**Subject:** RE: 24/0768/FUL & 24/0769/LBC - Southcombe Farm, Axmouth

**From:** Validation (EDDC) <validation@eastdevon.gov.uk>  
**Sent:** Tuesday, April 16, 2024 1:15 PM  
**To:** Tom Whettingsteel <tom@ndmarchitects.co.uk>  
**Cc:** Validation (EDDC) <validation@eastdevon.gov.uk>  
**Subject:** 24/0768/FUL & 24/0769/LBC - Southcombe Farm, Axmouth

Site Plan and Location Plan

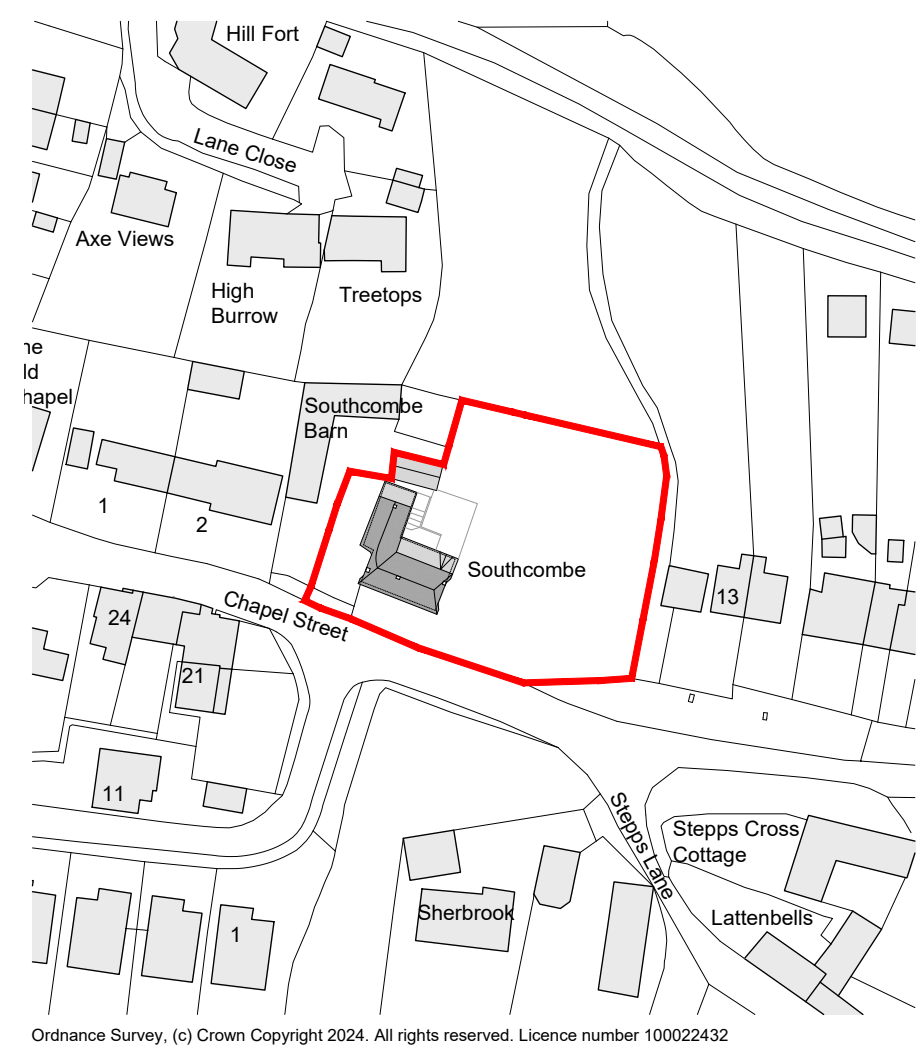
- **Site Plan** – Please annotate with arrows the Heat Pumps for absolute clarity [same as for the PV panels]

In accordance with your email below and previous conversation please find attached revised site plan highlighting the location of the PVs and ASHP and revised elevations which highlight the ASHP and PV's. I have also included technical brochures for the PVs and Heat Pumps.
